Change of use of land from agricultural field to 60 No. tent pitches operating from April to October to include 2 No. plumbed screened portable showers, 2 No. plumbed portable toilets, 2 No. screened changing cubicles, 2 No. 2 screened portable chemical toilets with hand wash facilities & washing up/drying area within existing building.

Woodpecker Camping Field Crookthorn Lane Climping

Thank you for your internet representation made on 8th May 2018 which has been recorded as '**an objection**' with the comments as follows:

block plan 1:500@A2

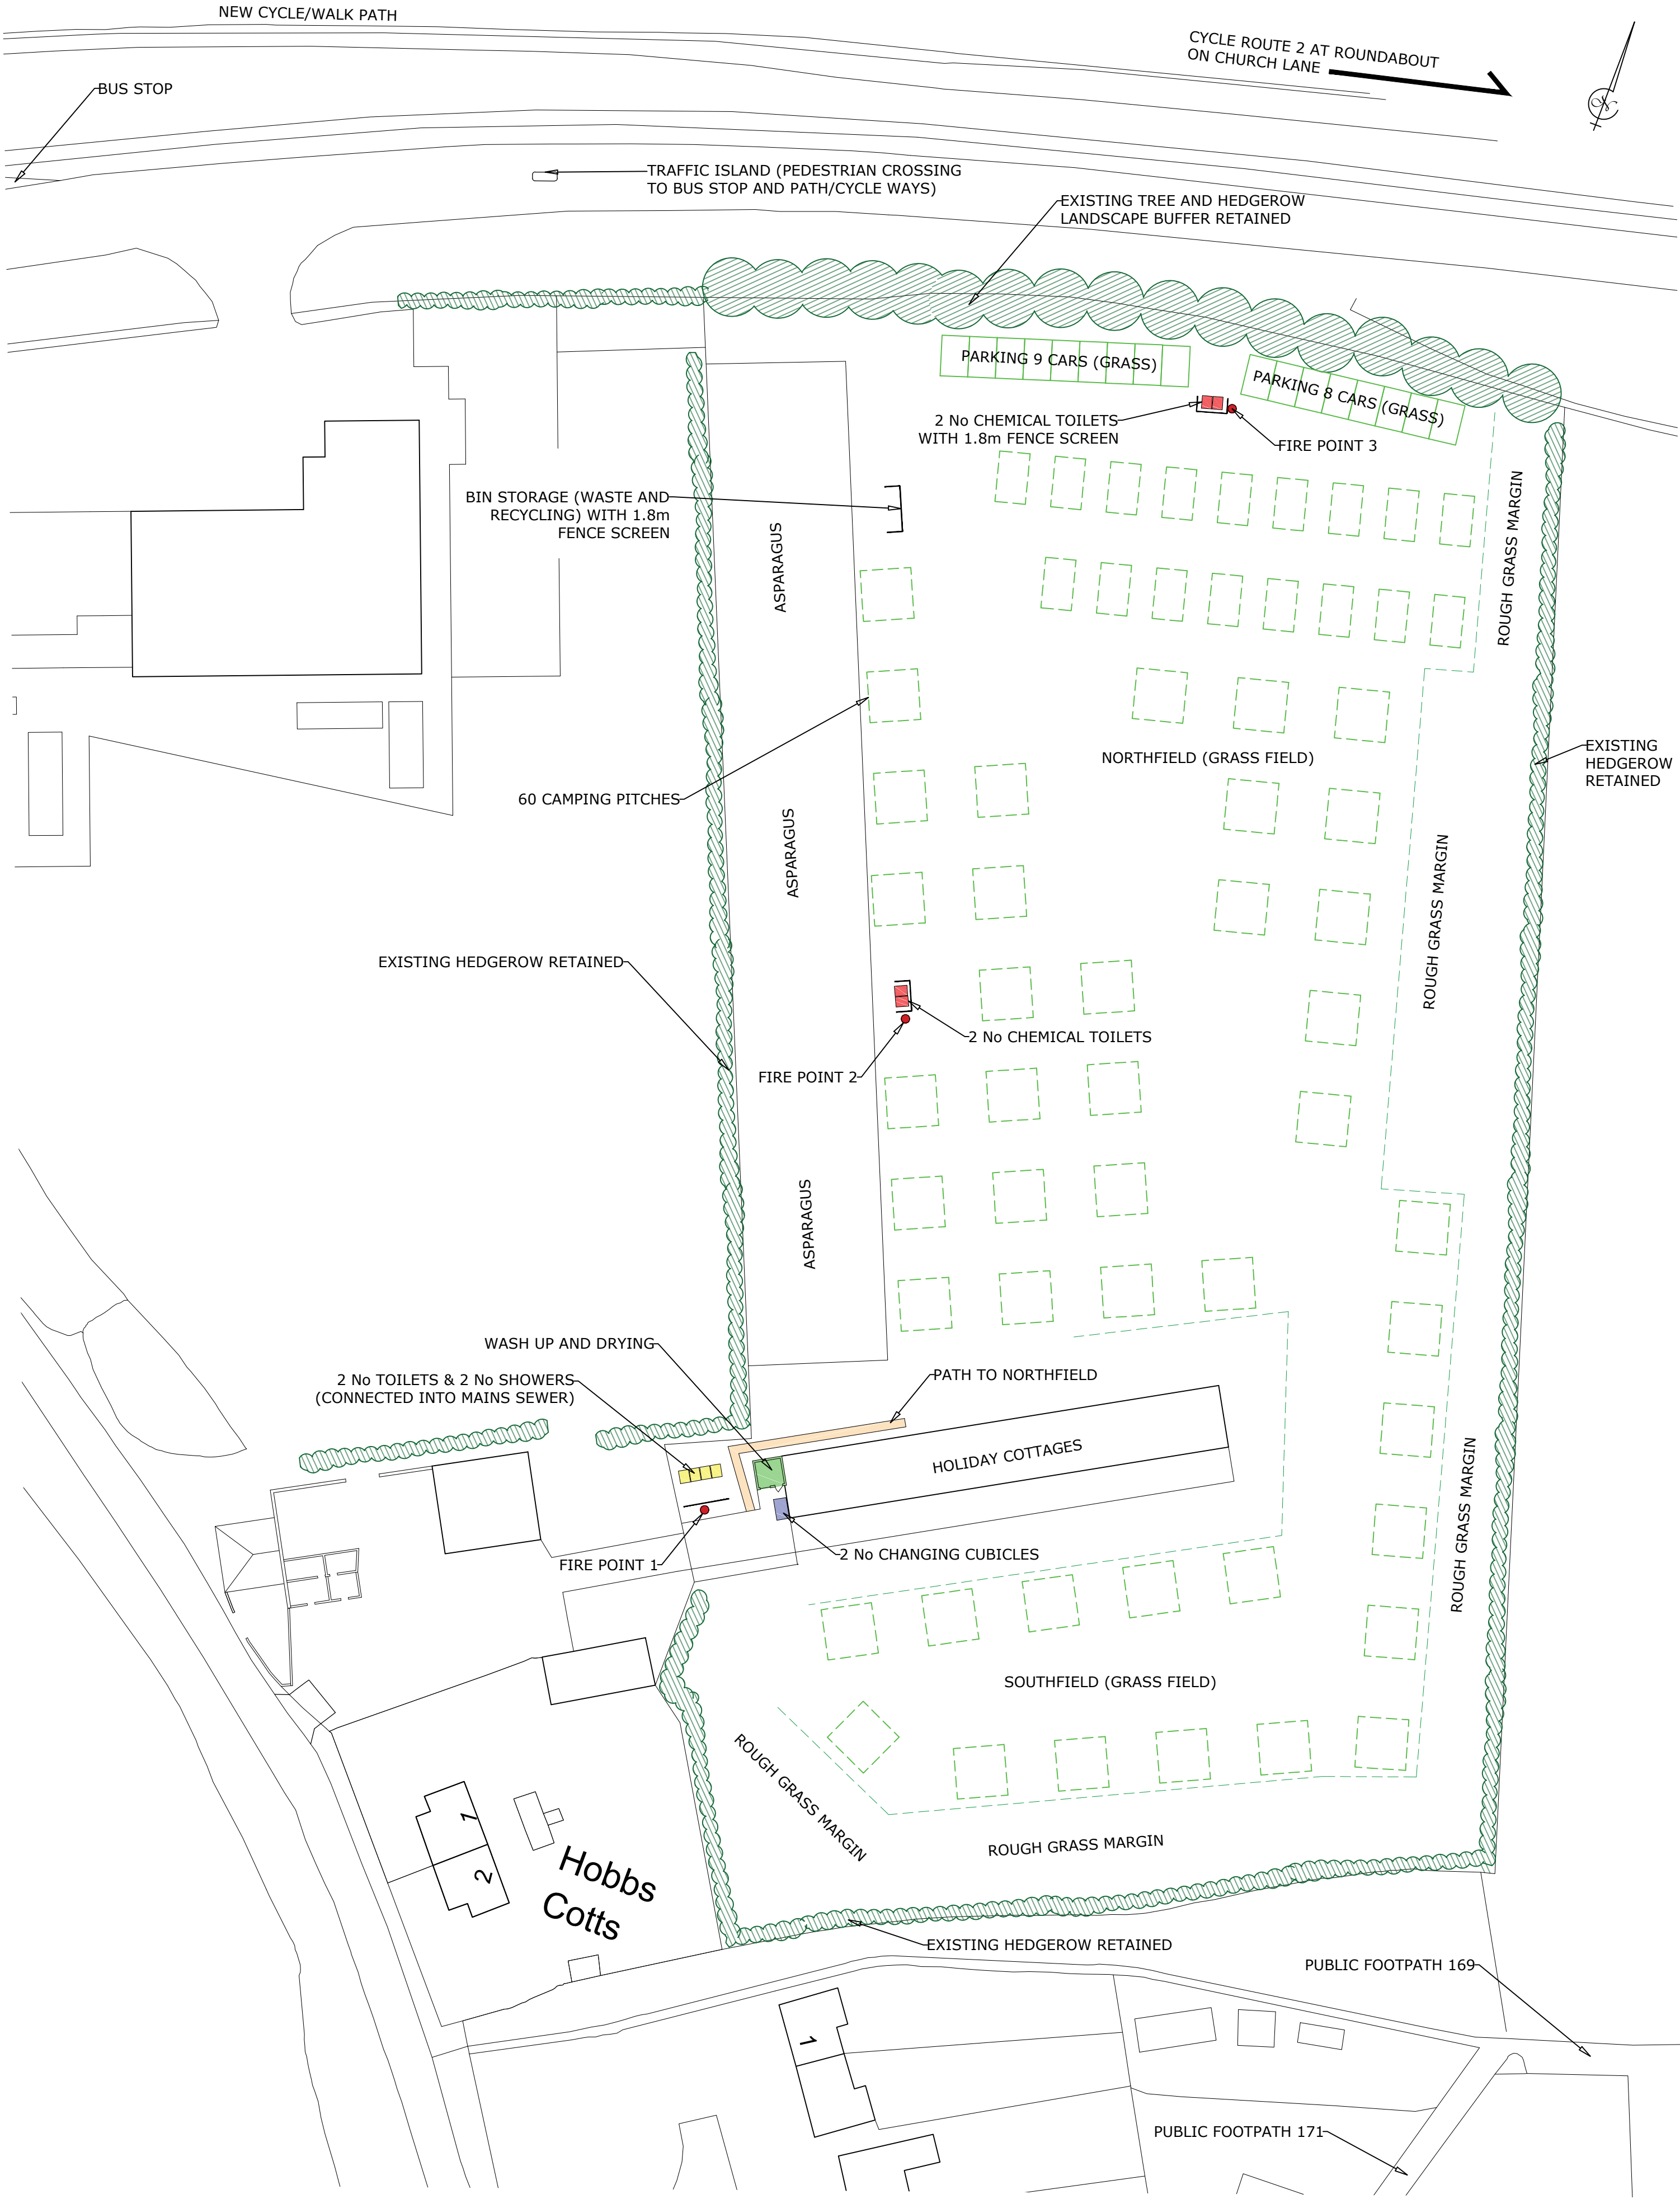
Many tents these days are on trailers which give greater privacy and carry their own Elsan type toilets - there is no provision made in the site plans for the hygienic disposal of said waste.

There is no provision for disposal of 'grey water' when the occupants decide to cook/wash up or clean their teeth in their tent area.

Many visitors will also have dogs with them - there is no provision for a 'dog walk' enabling the animals to relieve themselves in a safe environment and not next doors tent pole.

Disposal bins for animal waste are also not on the plans
